Erection of a wall, fencing and gate to property.
4 Seaview Road East Preston

Thank you for your internet representation made on 1st April 2020 which has been recorded as '**an objection**' with the comments as follows:

I am commenting on behalf of East Preston and Kingston Preservation Society

1:45

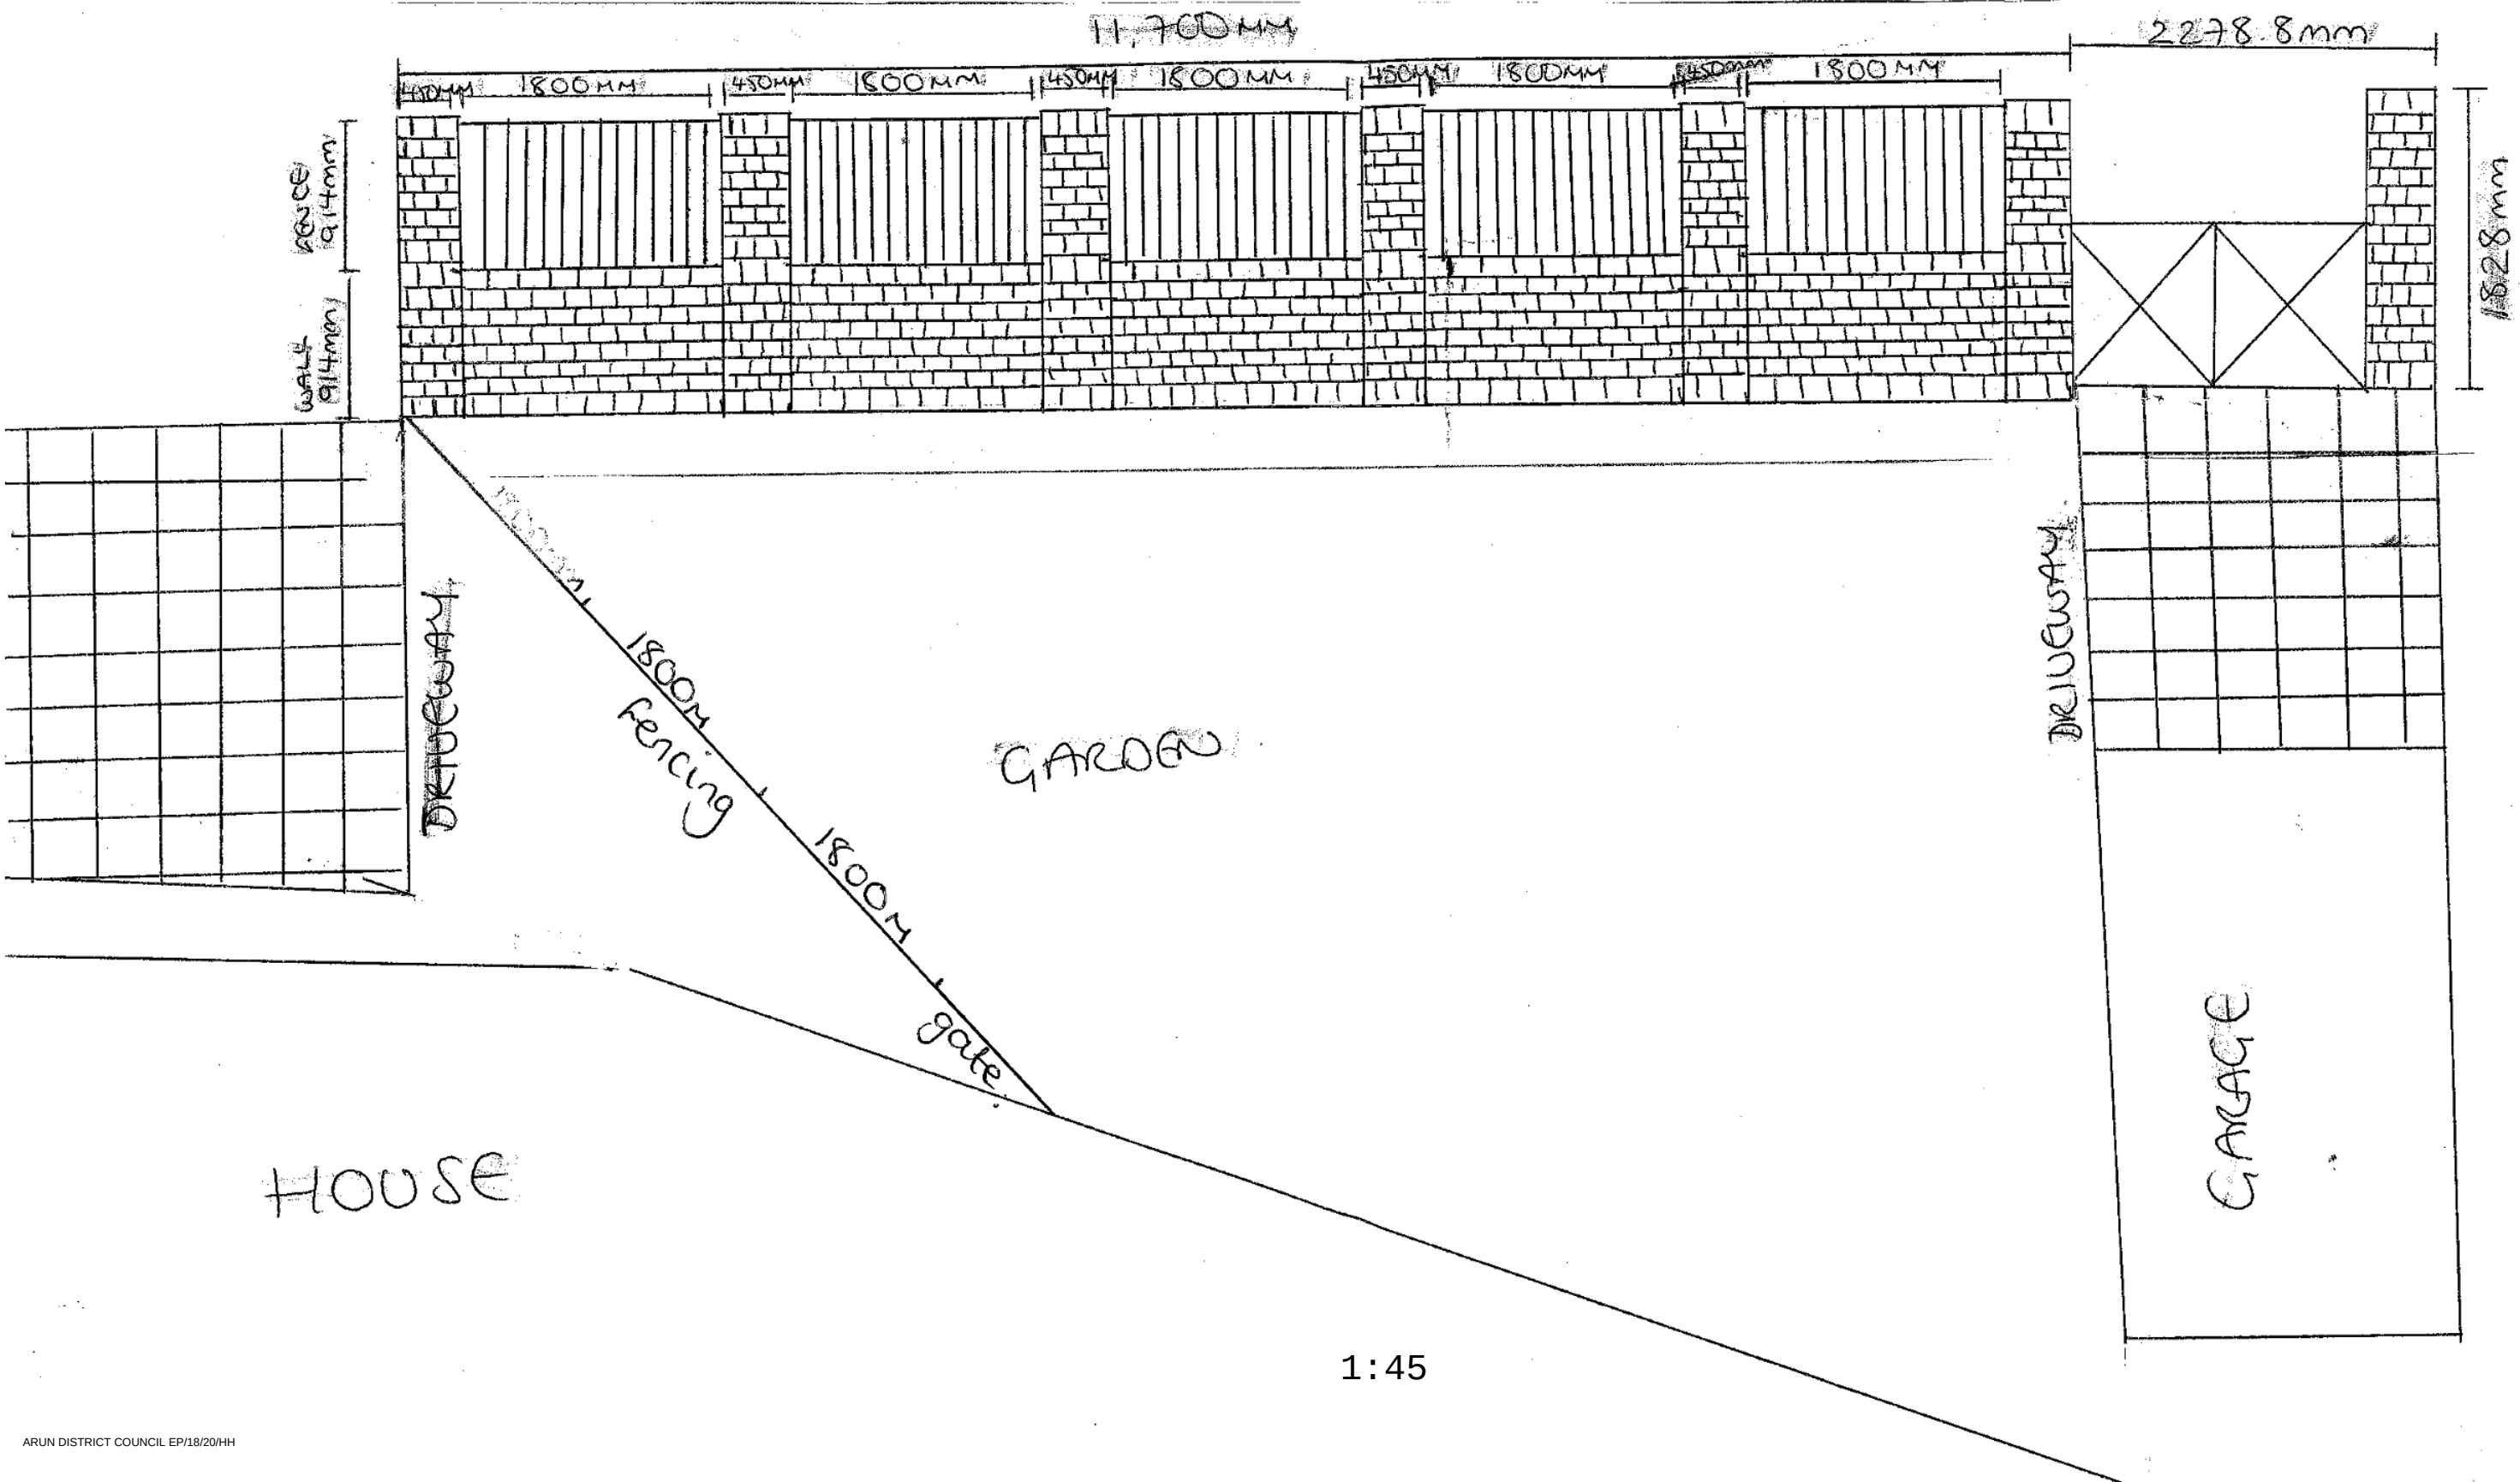
The proposed wall and fence would be higher than other front walls in Seaview Road. It is a road that has retained a considerable degree of uniformity in its appearance, the houses having originally been built to a similar design with low front walls. The proposed wall would disrupt the broadly harmonious appearance of the road.
